Re: **Pier Center 1/3 Issue**
Location: Lot 8 Cotton Farms (240 Deer Tail Lane Fuquay-Varina, NC)
JDS Project No.: RDU2310500
Date of Inspection: 11/1/23

A representative of JDS Consulting arrived on site to observe the issues reported to us by the client, which are presented, along with our recommendations, in this report.

FOUNDATION STRUCTURAL PLAN

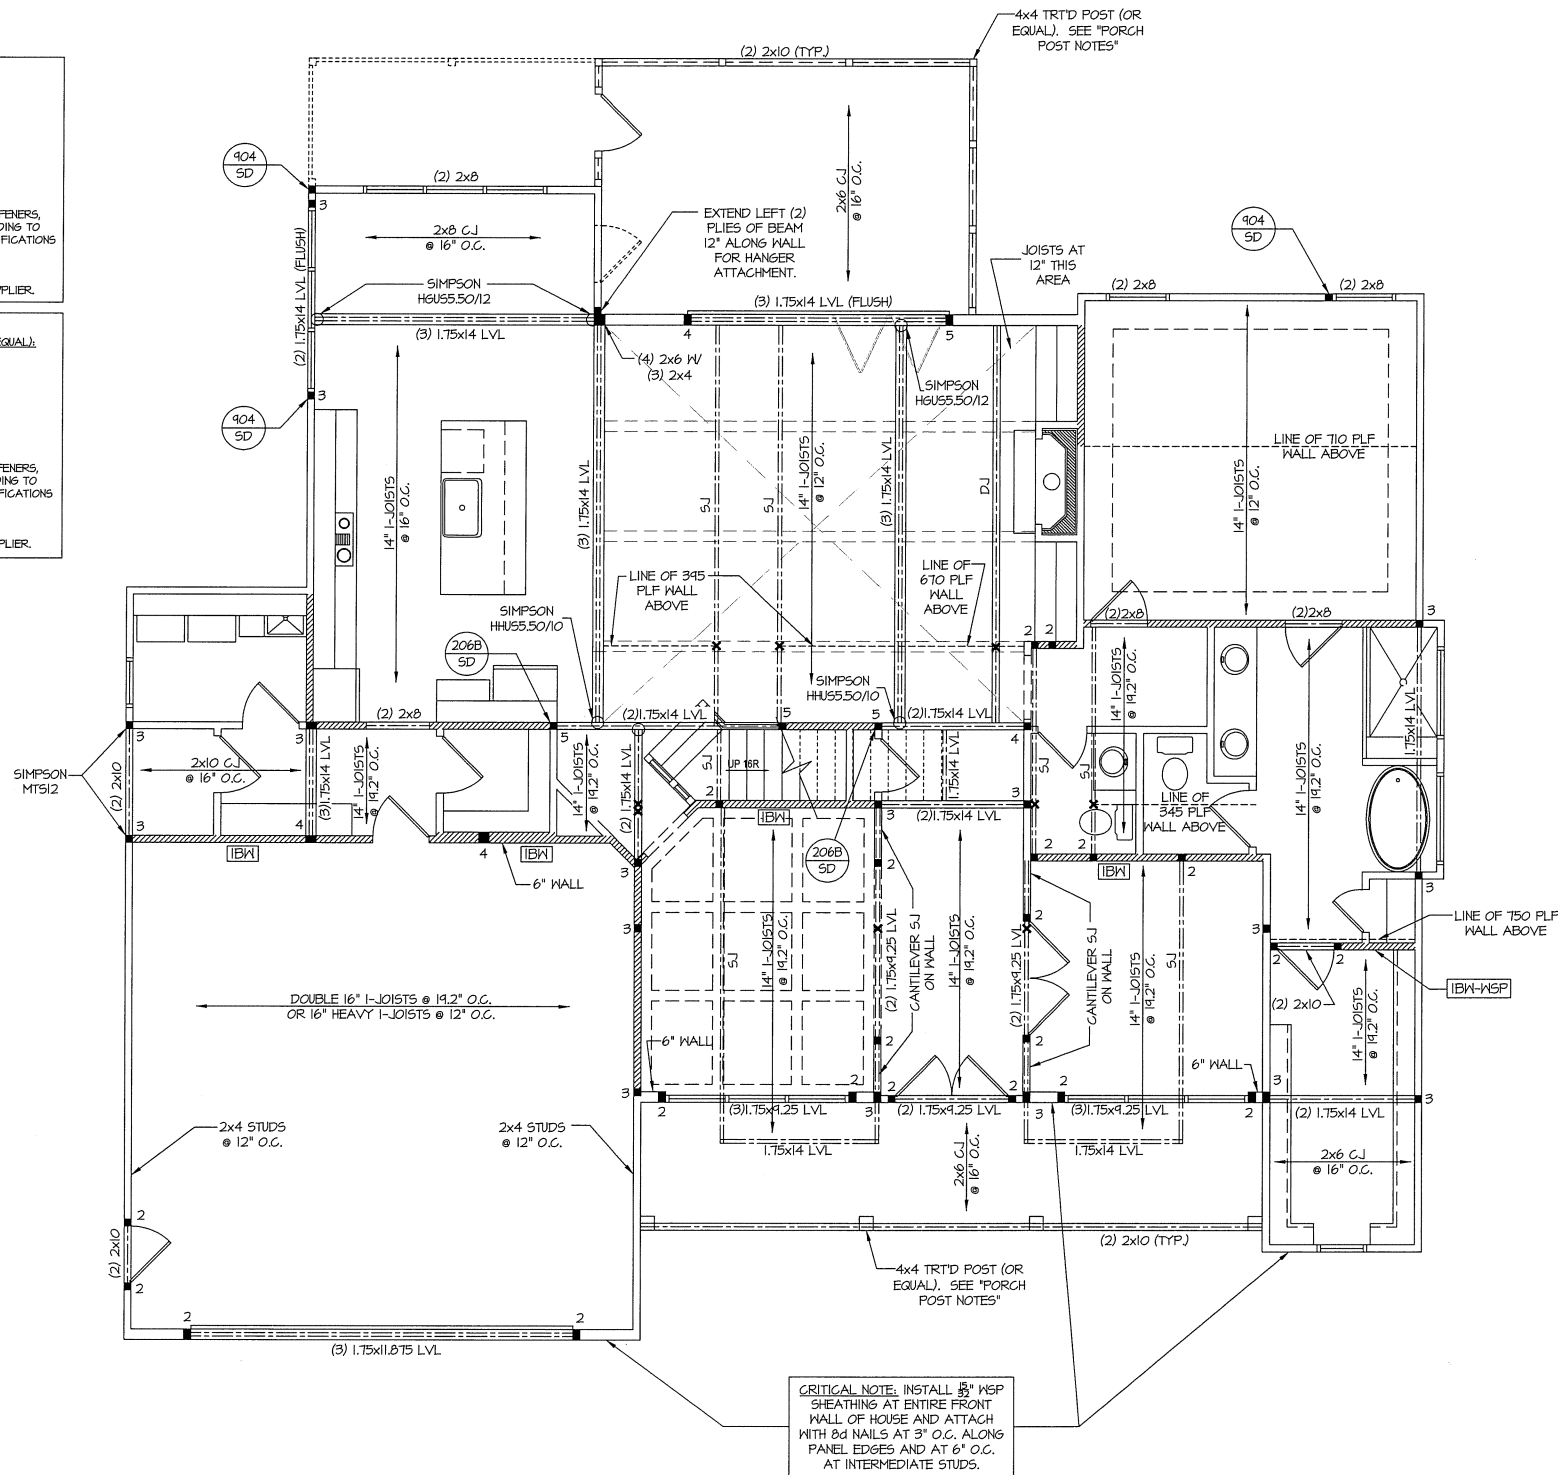
The client has requested evaluation of the first from the left pier in the 4th row from front not sitting within center third of the footing from front to rear per the inspector. The pier was 16" across with front projection of 4" and a rear projection of 13" beyond the pier.

Based on our onsite observation and review the pier observed is within center third of the footing below. No further action is required.
